From: Simon <[REDACTED]>
Date: 9 January [REDACTED]
To: Gary Chisnall <[REDACTED]>
Subject: Fwd: 52 - 56 Ferring Street, Ferring, West Sussex BN12 5J P - FG/118/16/BR

[REDACTED]
Subject: 52 - 56 Ferring Street, Ferring, West Sussex BN12 5J P - FG/118/16/BR

FAO David Akehurst

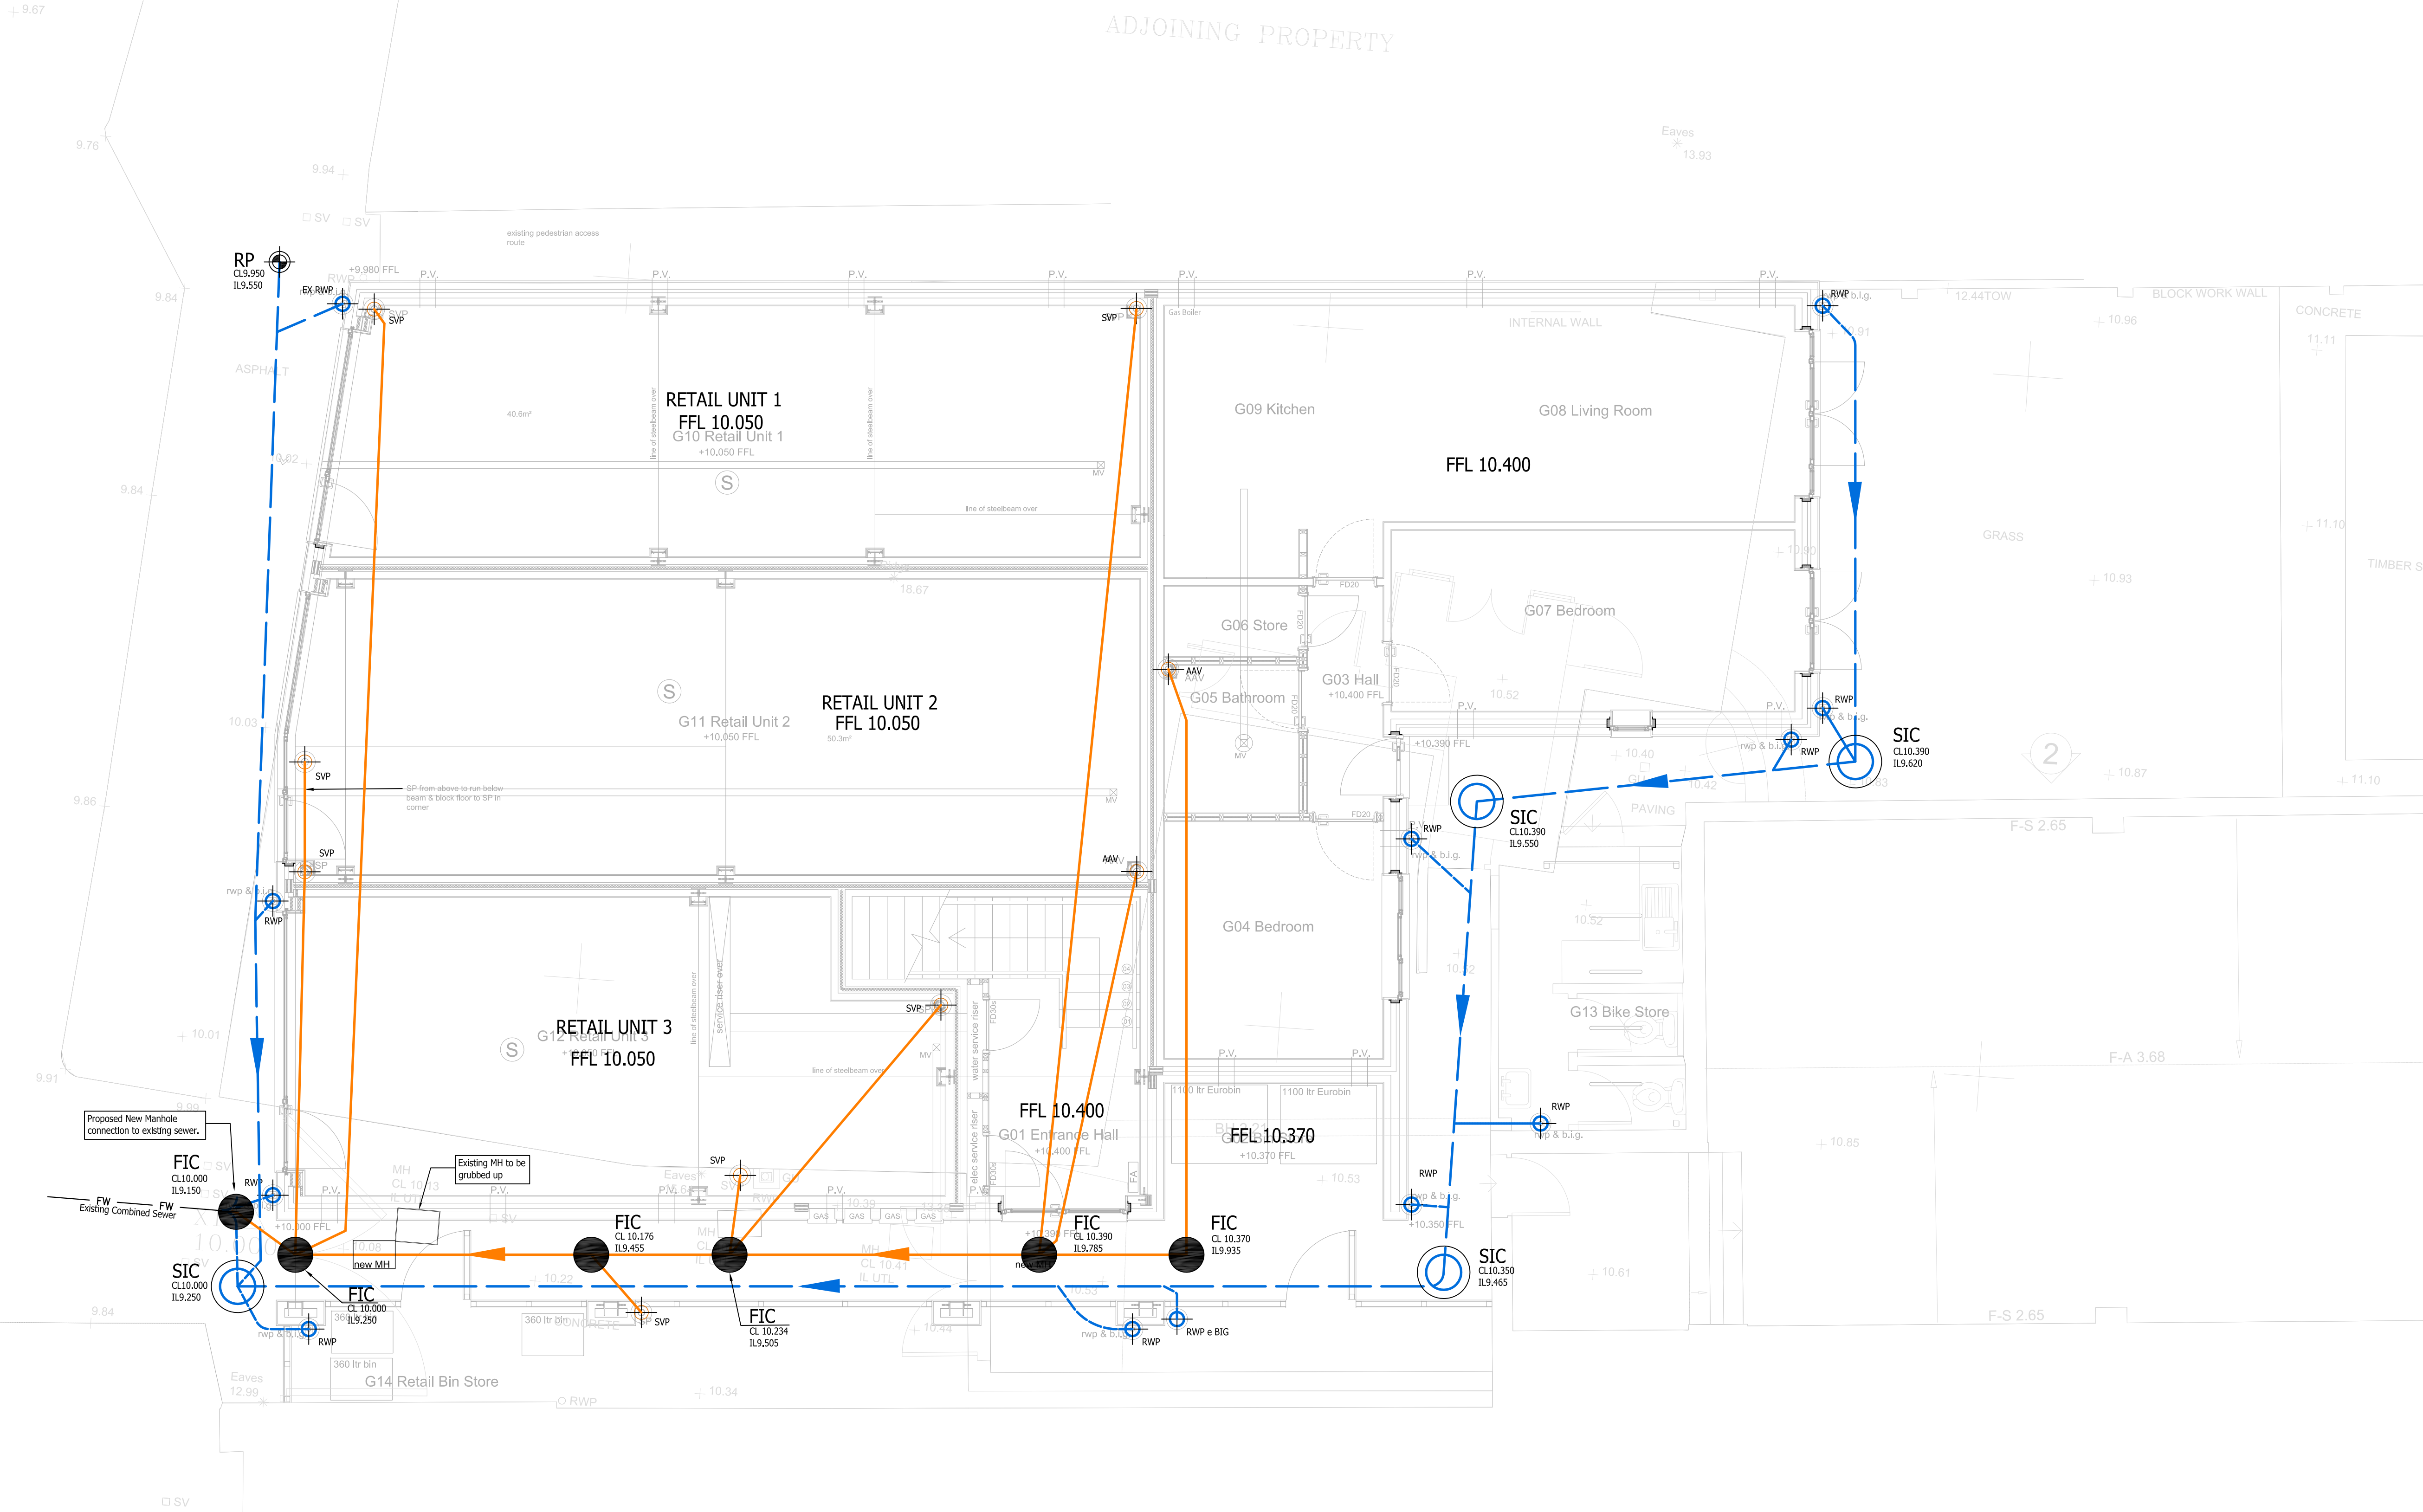
Unfortunately I have had to rule out the option of a soakaway for this site. Not because of the new building, which could have been built on piled foundations, so that a soakaway could be built in close proximity to the new building, but because of the proximity of the foundations to the existing buildings on either side and to the rear that have shallow traditional foundations (a large soakaway would inevitably encroach inappropriately close - a deep soakaway is not possible as it would undermine foundations, and would not be effective as the water table can be high in this area). The site is effectively land locked, so options are limited.

There are no watercourses in close proximity to the site. The map of sewers does not indicate the existence of a dedicated surface water sewer system in the road or close to the site.

It would appear that the original building and the adjacent buildings all discharge surface water to the foul sewer system.

If the surface water drainage was to continue to discharge to the foul system it would need to do so via trapped gullies to comply with the Building Regulations (so that the sewer is not ventilated via the rainwater pipes).

Obviously the decision whether the surface water can continue to discharge to the foul sewer is entirely yours. For my purposes the site is substantially no less compliant than it was previously.
